November 25, 2020

Sand Creek Center Tributary Channel Improvements
Initial Corps direction is to apply for a

SOLACE APARTMENTS - SAND CREEK CENTER TRIBUTARY

CHANNEL IMPROVEMENTS

SHEET 8 OF 10  
JOB NO. 25174.00

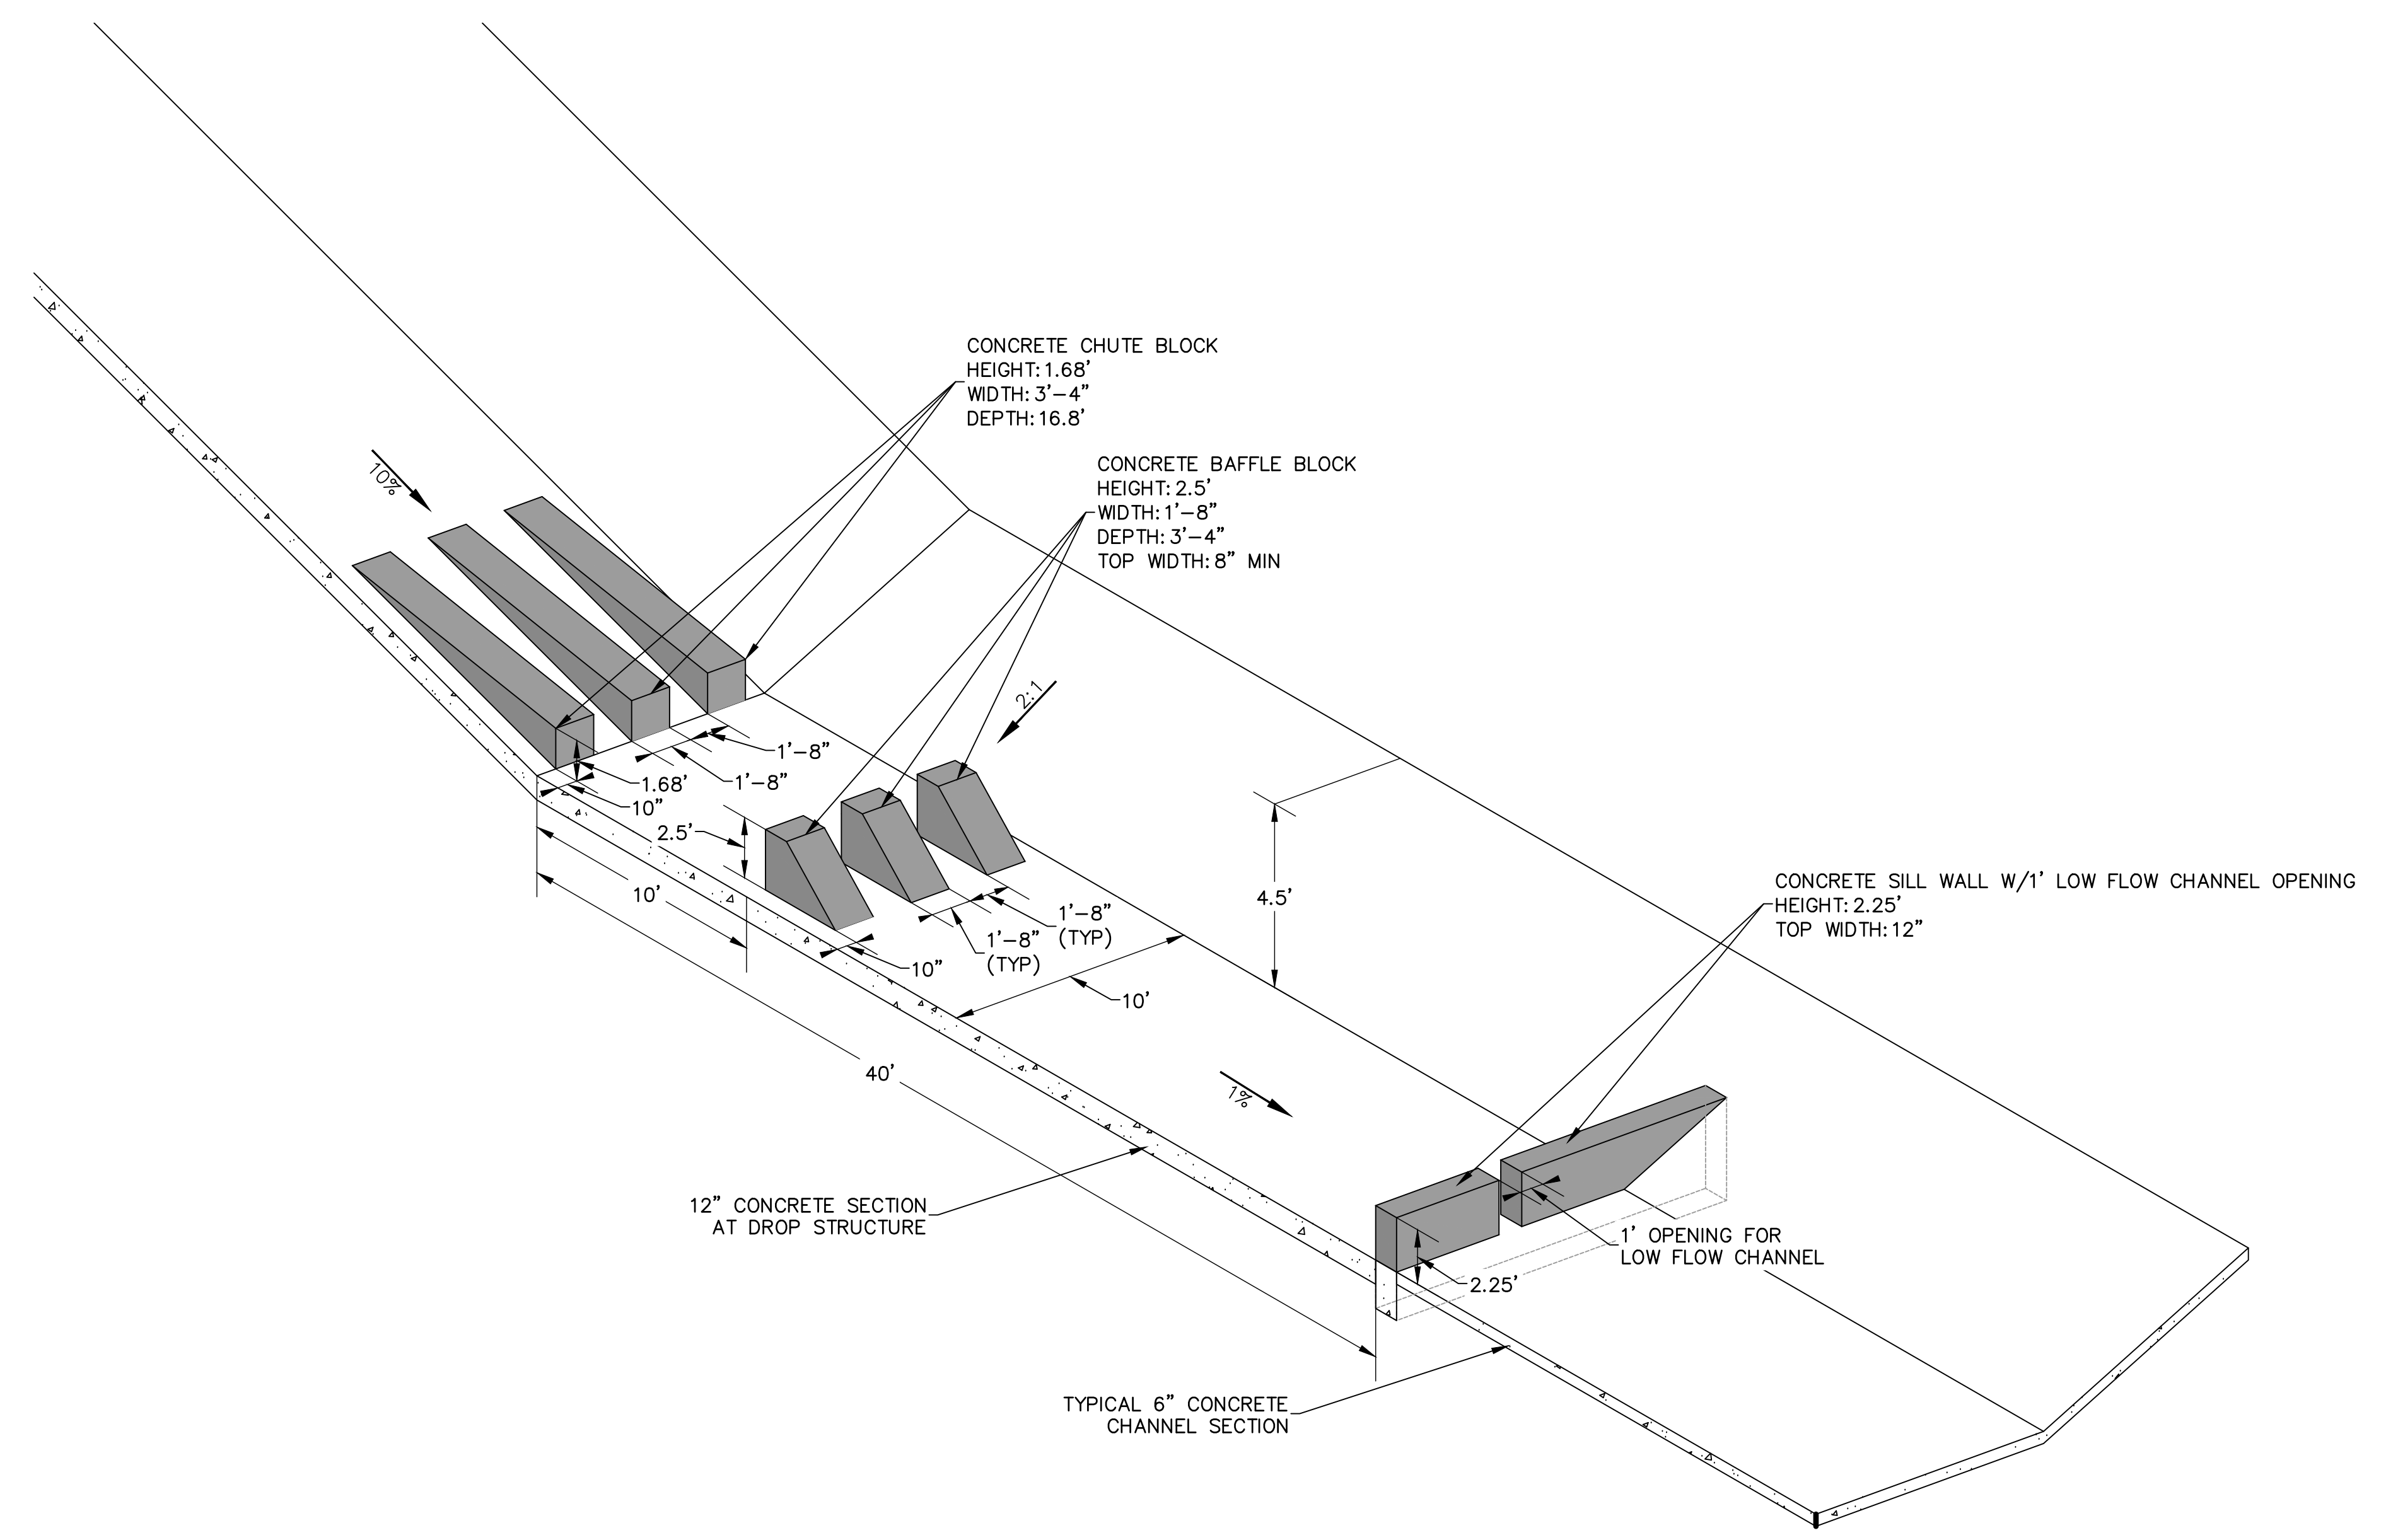
The details only indicate 2 chute blocks. Please revise the details and/or calcs accordingly.

Only 2 baffle blocks are indicated on the detail. Revise accordingly.

SAND CREEK CENTER  
 TRIBUTARY  
 PAONIA STREET OVERFLOW  
 PLAN

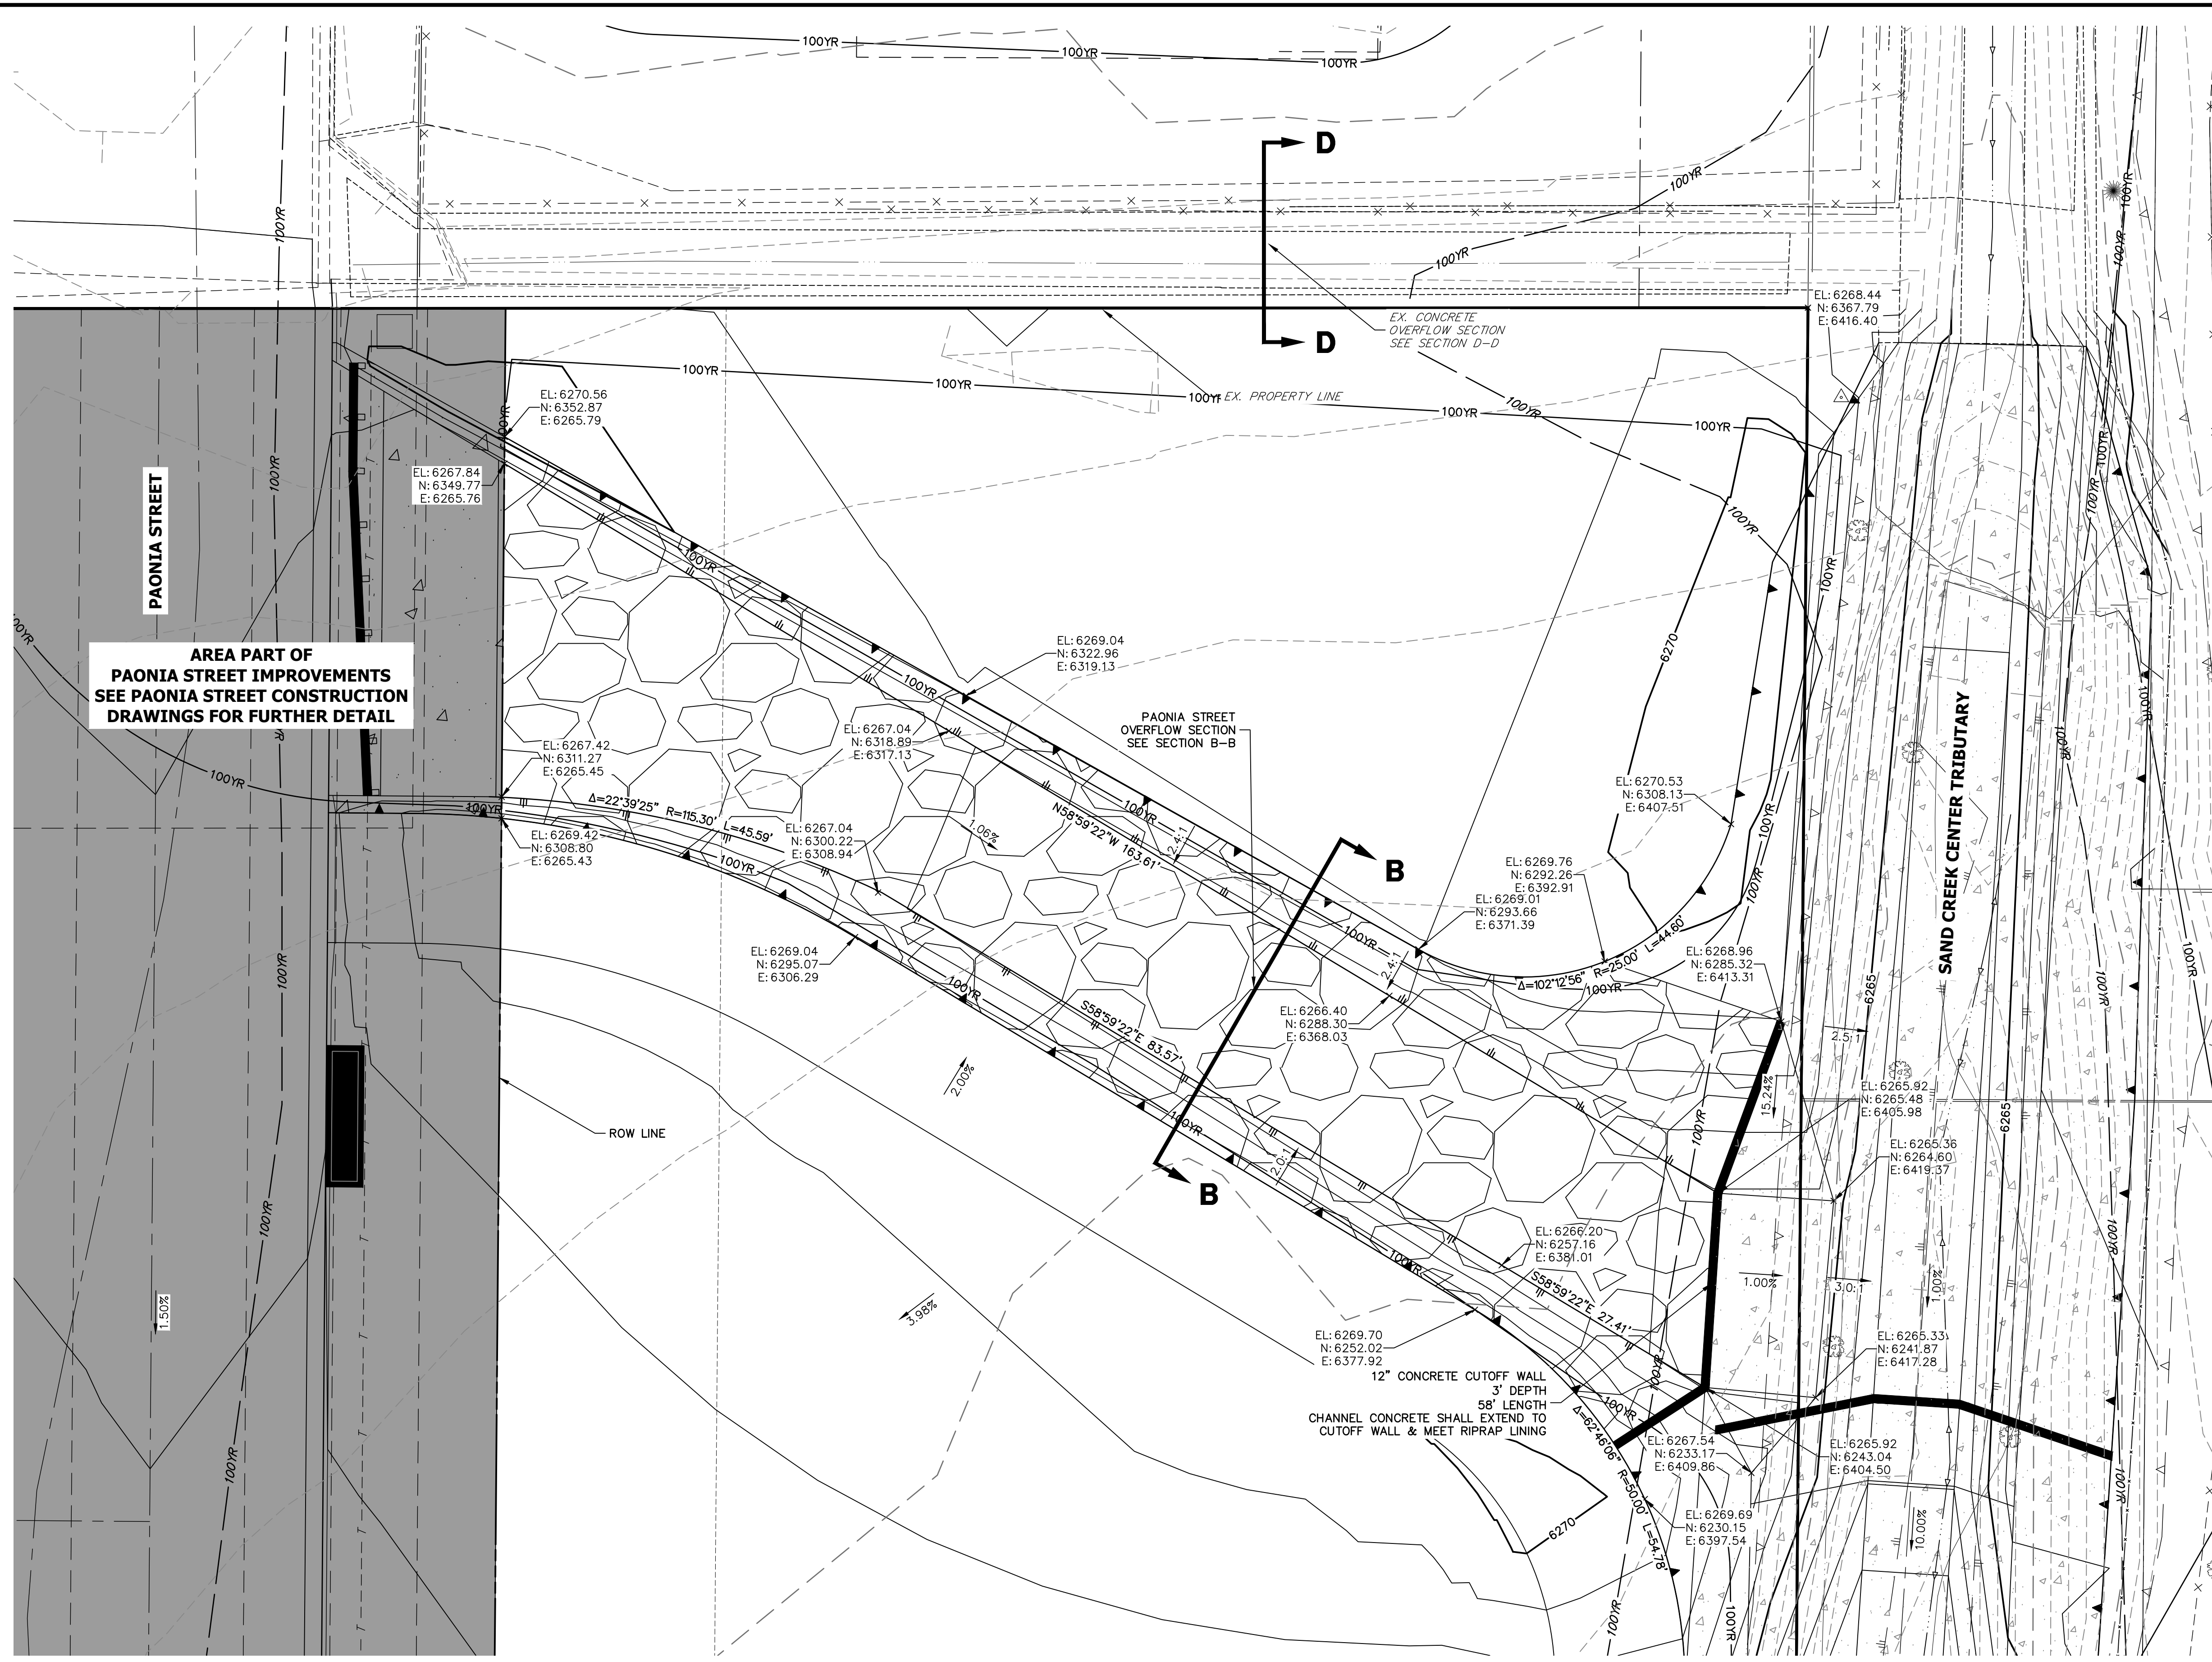
Please discuss how the overflow along the existing Paonia street will be diverted to the this overflow channel. Additionally, Please indicate the bypass flow that will enter the two inlets. Does the roadway have the capacity for this bypass flow? Please address.
